CITY OF PORTLAND

September 16, 1999

RE: 130 Highland St. 123-F-018 R-5 zone

Proposed deck

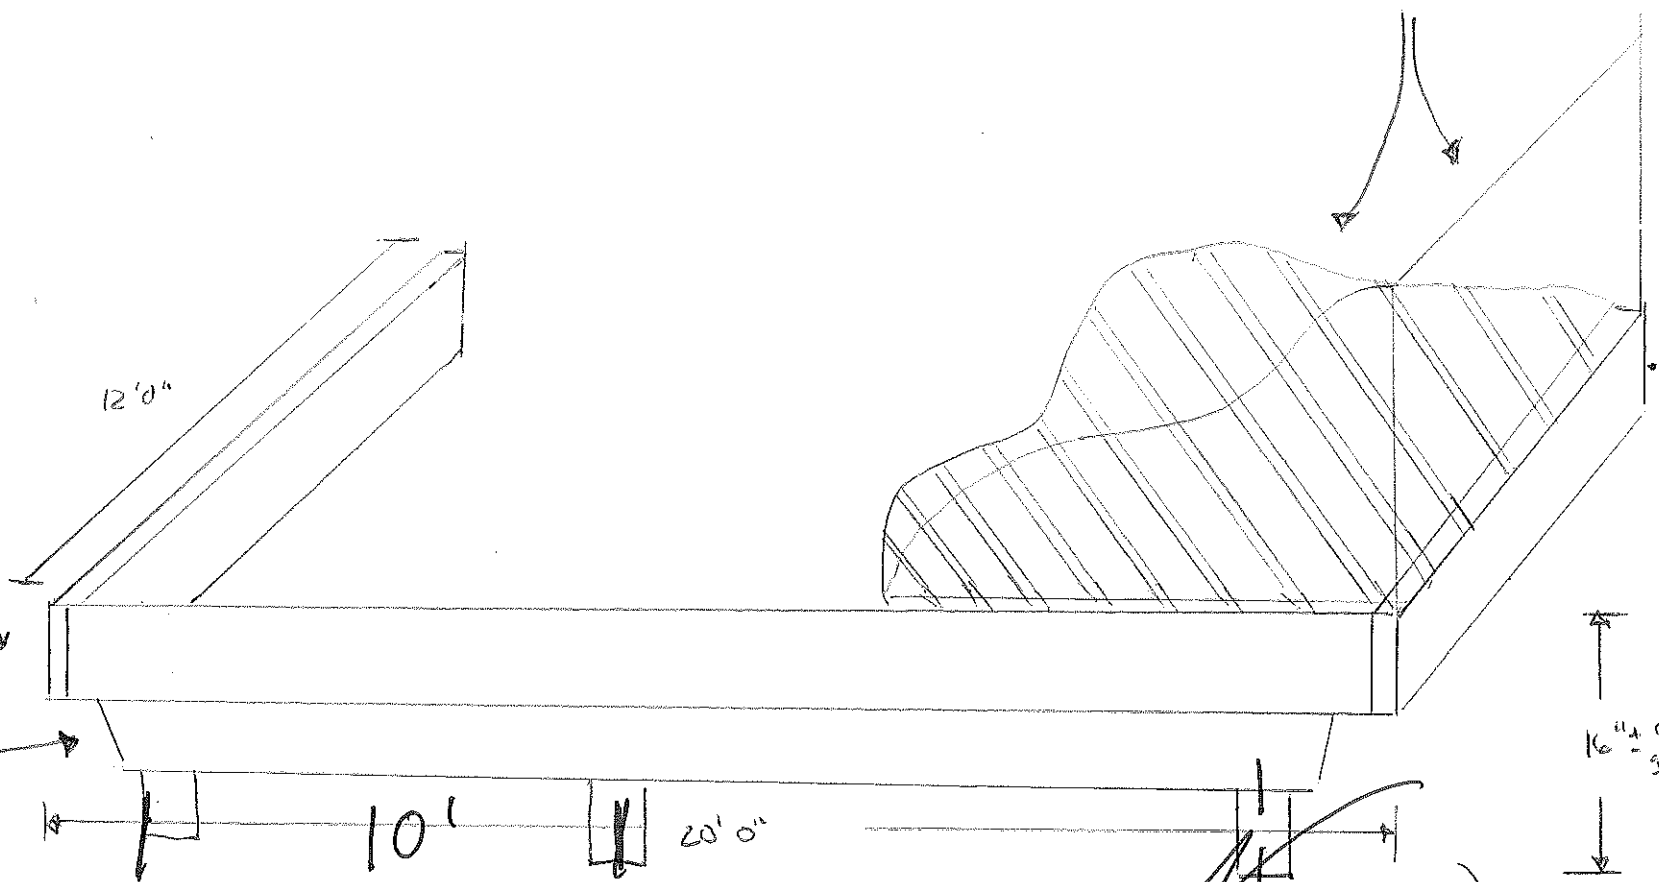
I am in receipt of your application to construct a 12' x 20' deck on the first floor. Your plans show that you have a 14' setback instead of the required 20' setback. Your permit can not be issued unless the zoning ordinance requirements can be met. I do have the ability to allow a 15' rear setback if you can show me good cause as to why you can not meet the required 20' setback. In any case, you would need to adjust your plans to reflect the required setbacks.
